SCOPING OPINION:

Proposed London Strategic Heat Main

Case Reference: EN0710009

12 August 2026

## **Figure 1-1: EIA Scoping Boundary**

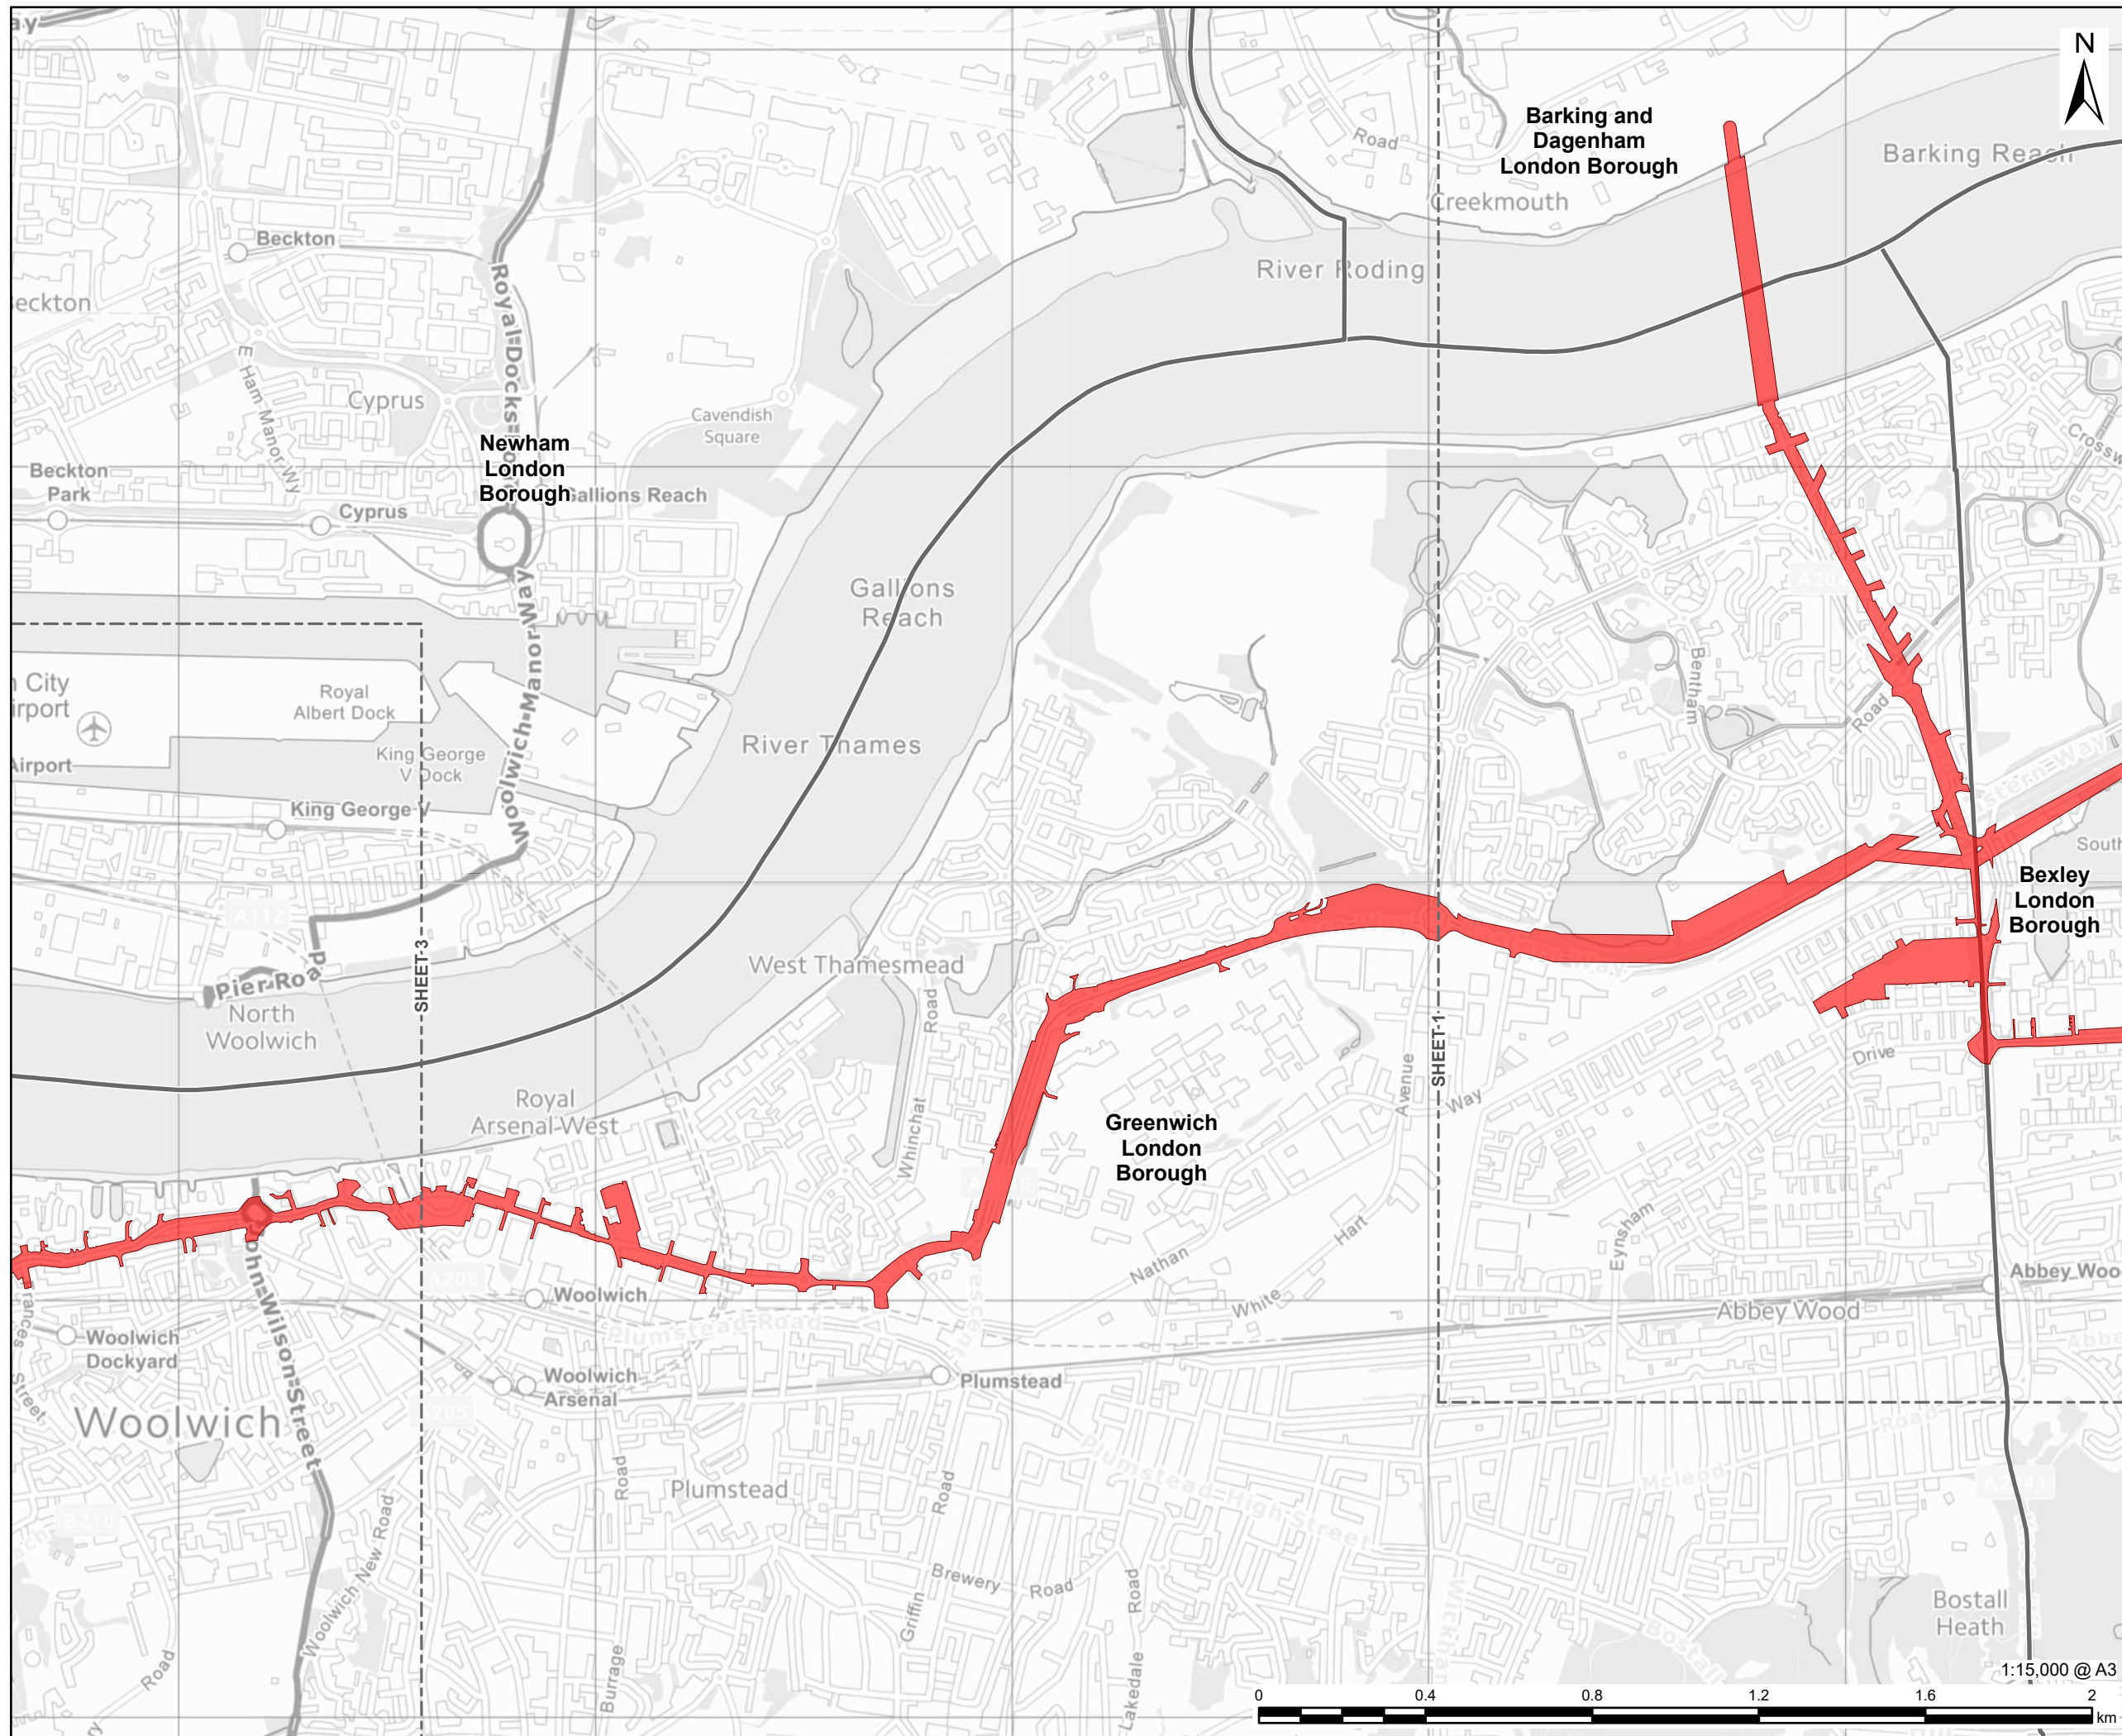
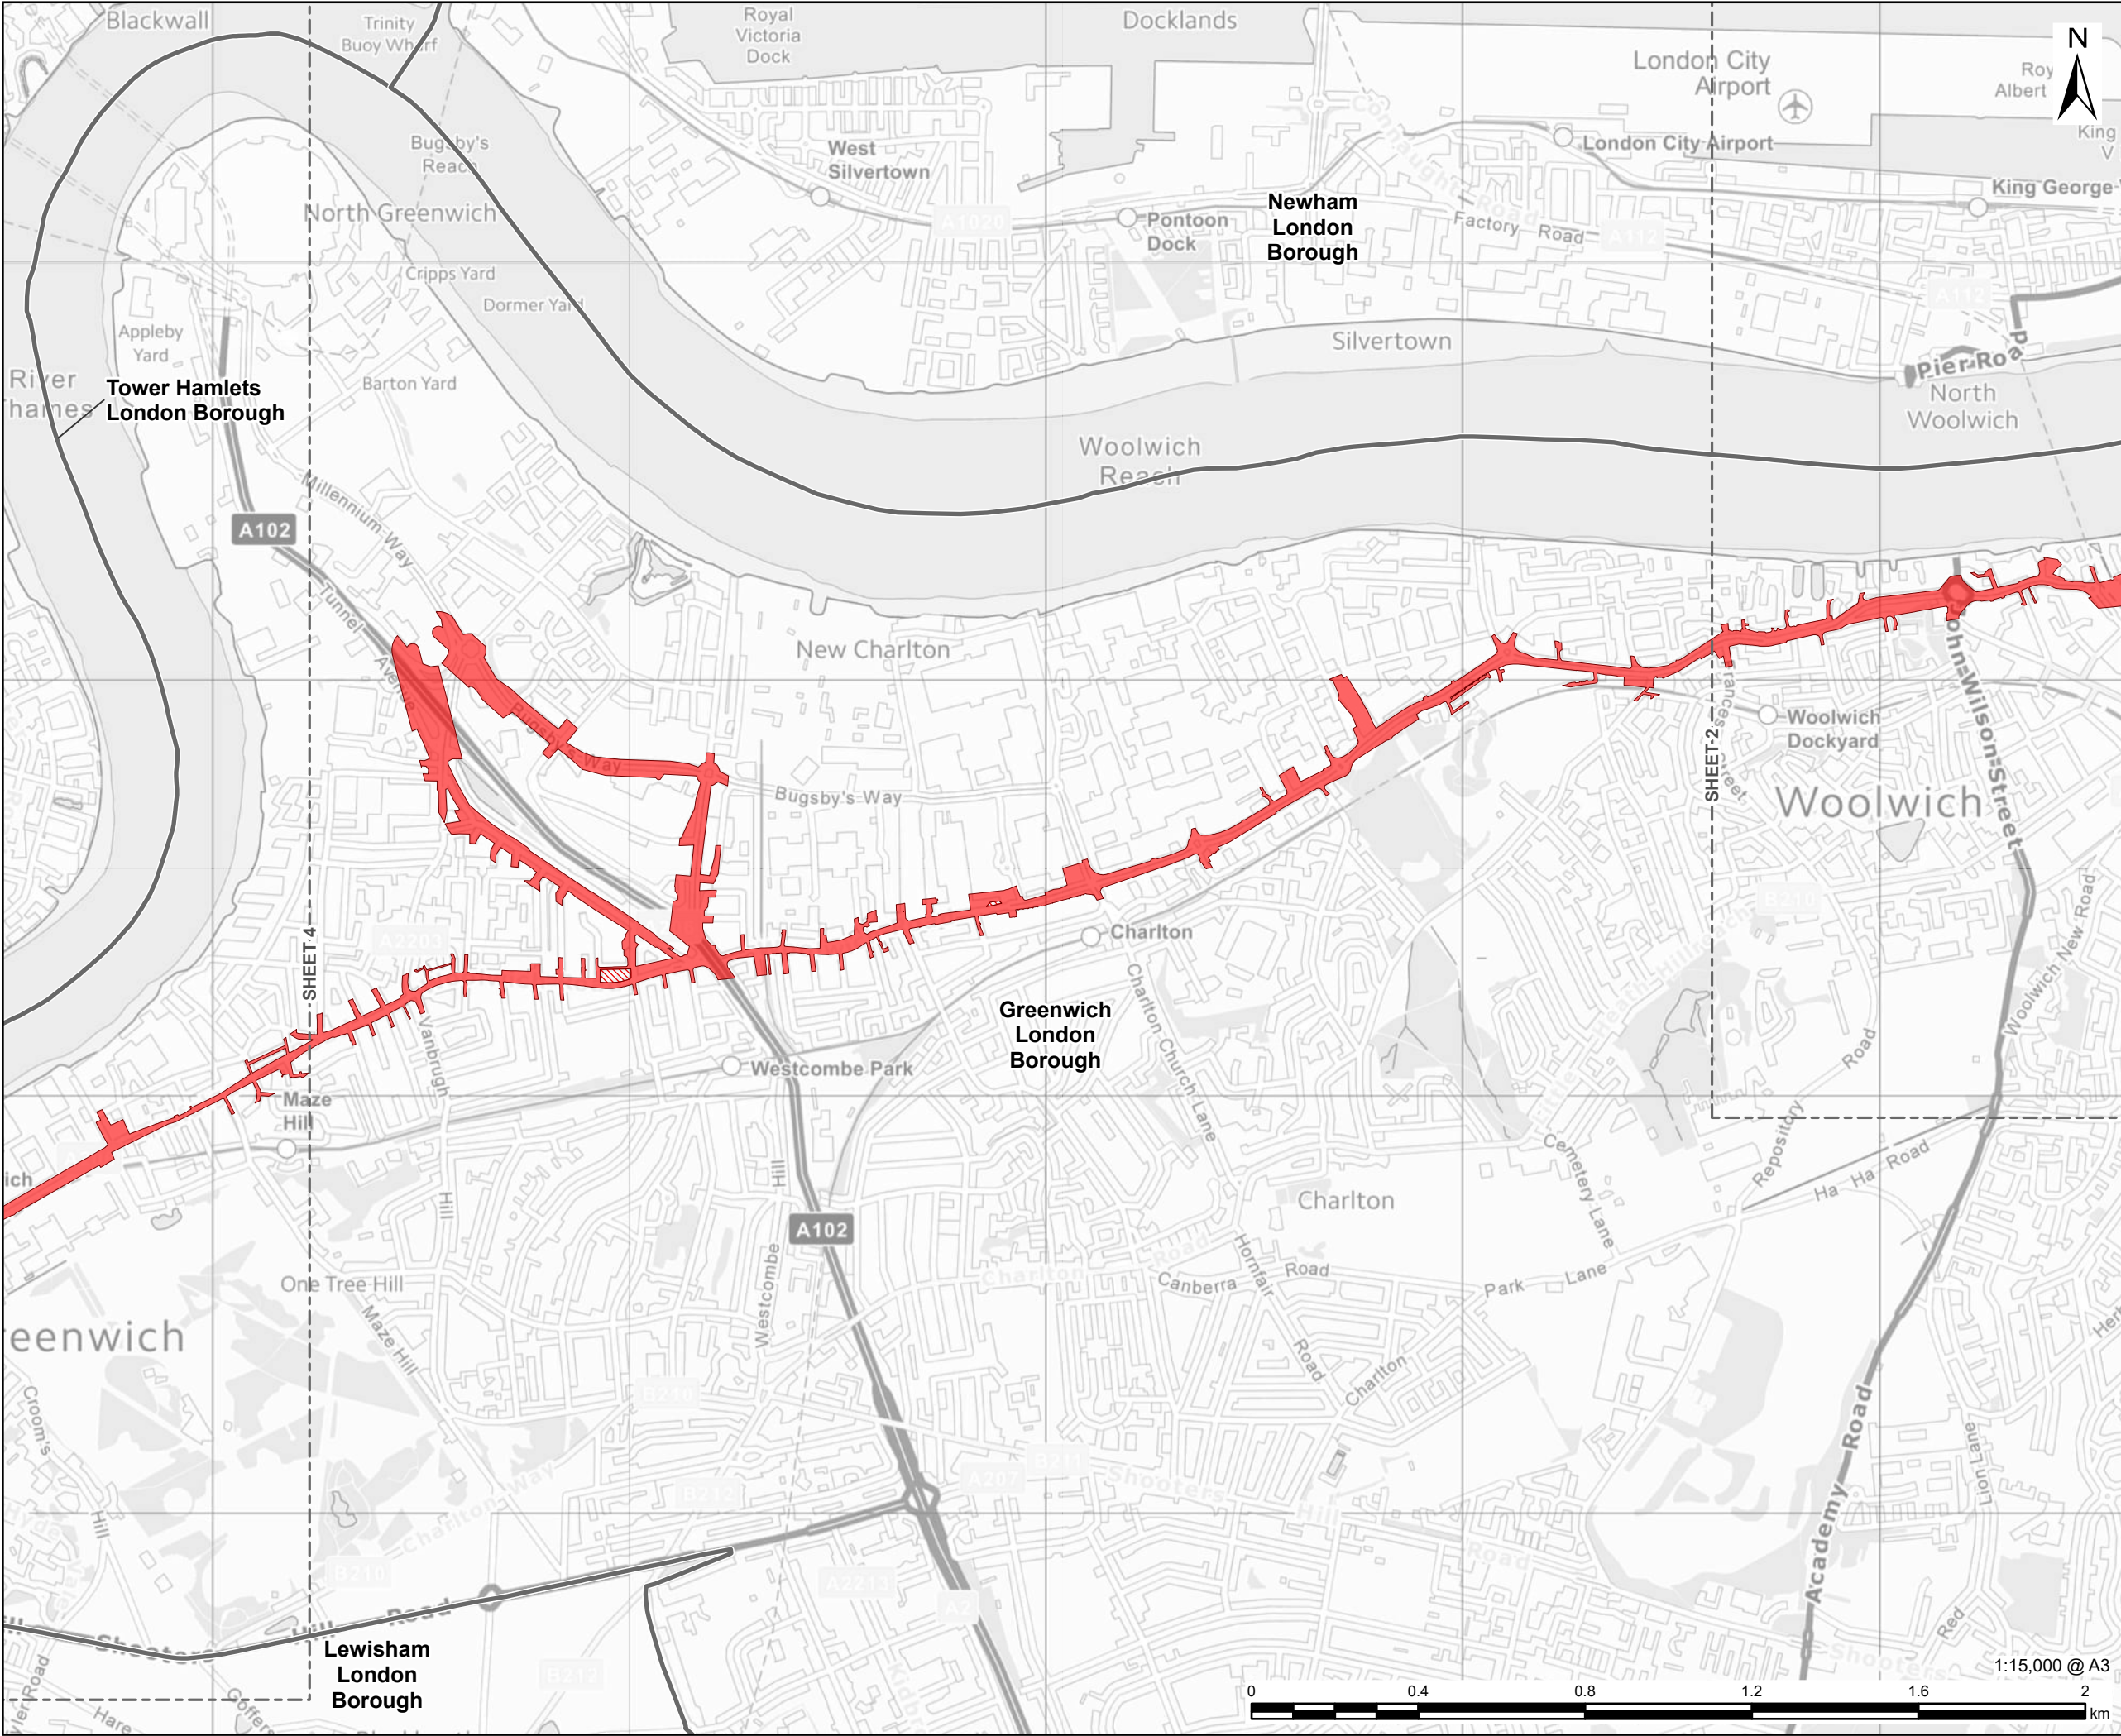
ID	Ref	Description	Inspectorate's comments
2.0.1	Figure 1-1	Scoping Boundary	The applicant should consider whether the figure could show the proposed development order limits within the scoping boundary, this would enable an understanding of the relationship between the proposed development and the scoping boundary. The scoping boundary should also clearly set out where this encroaches into the river Thames itself.
